Comments on

Snapper Mine Northern Extension Modification - Submissions Report

TRONOX
S N A P P E R M I N E
Revised Modified Snapper Mine -
Indicative Final Landform

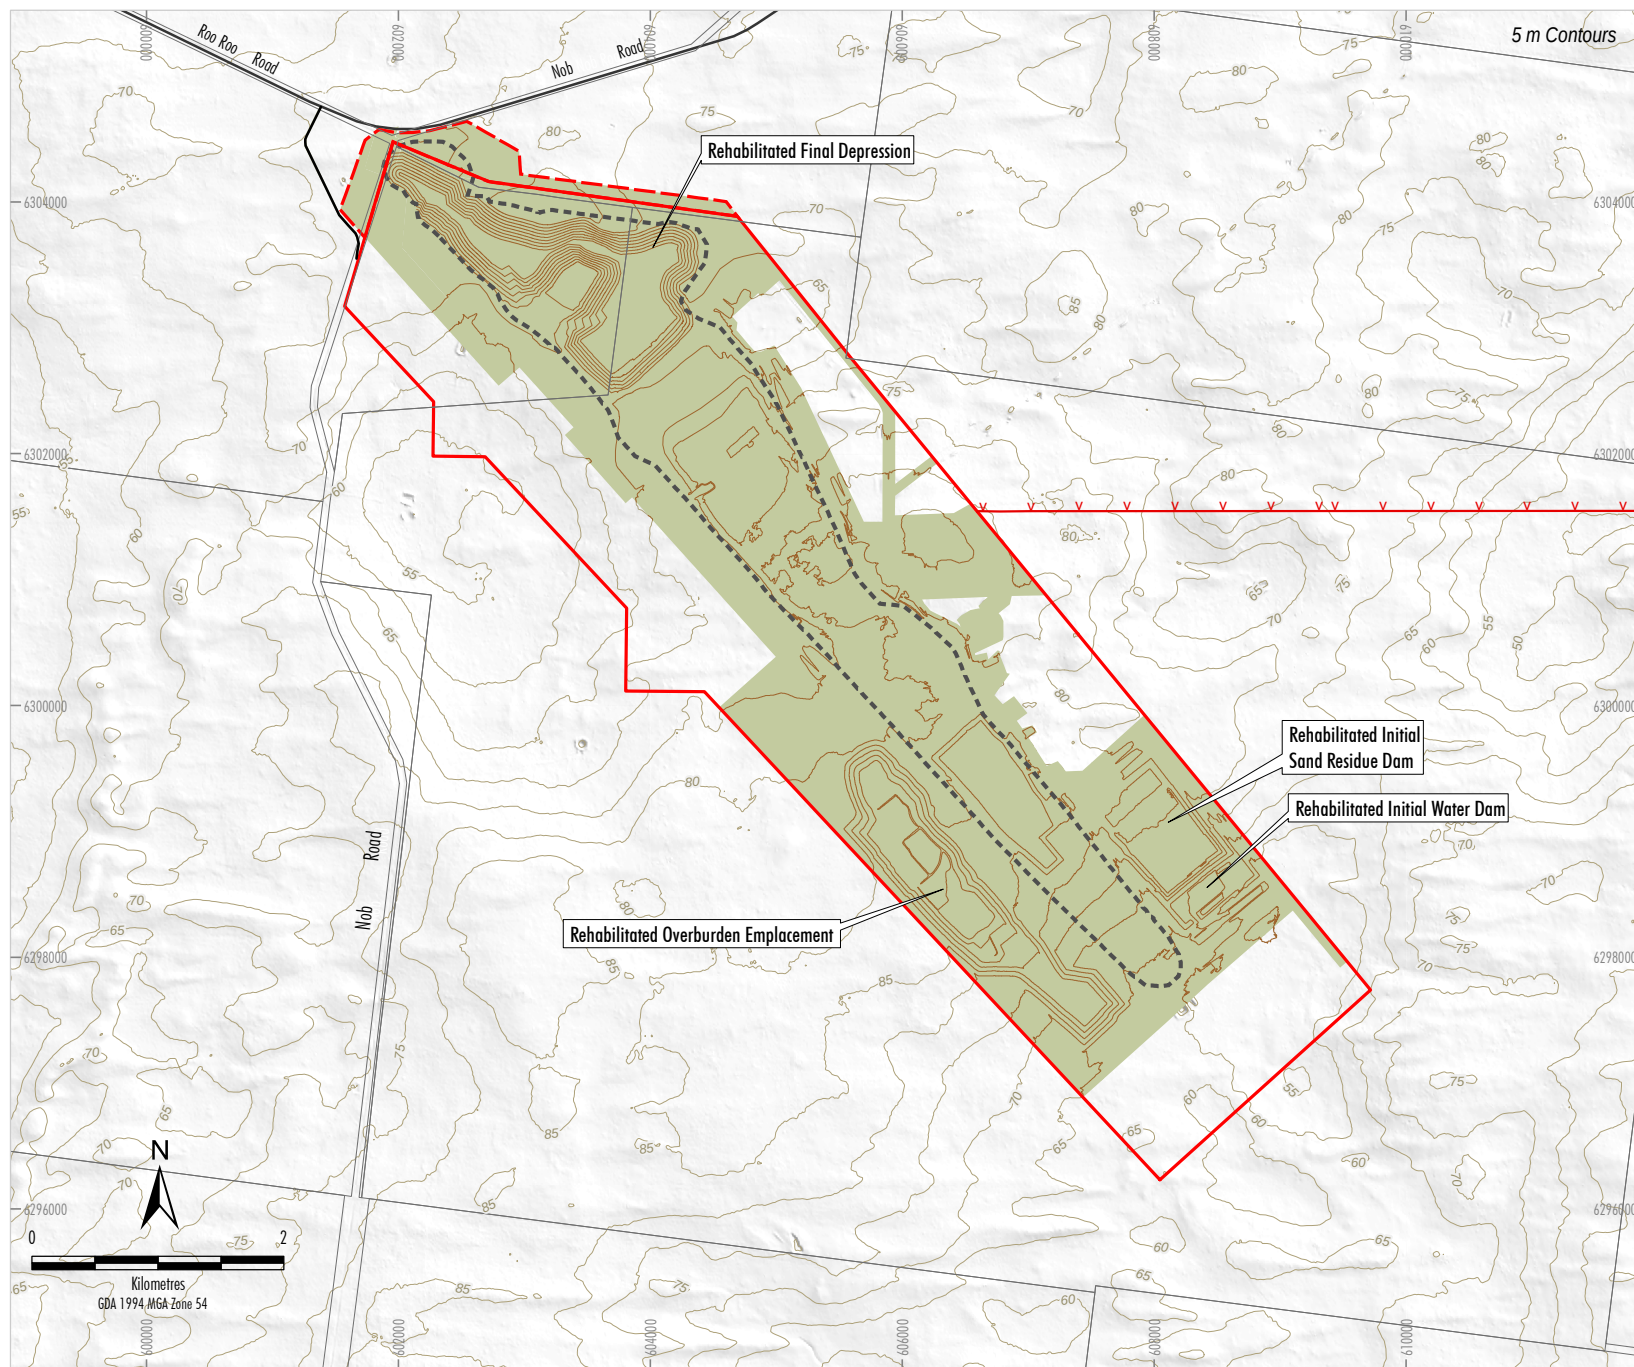
It appears from the Submissions Report there will be no final depression in Manilla Station. From 4.2.2 Rehabilitation and Land Use Response 5 it seems our land will be left; "safe, stable and non-polluting and would be integrated with the surrounding landscape" This is a big improvement on that proposed in the Modification Application and we thank Tronox for making those changes. Irrespective of that the land will be forever changed by mining.
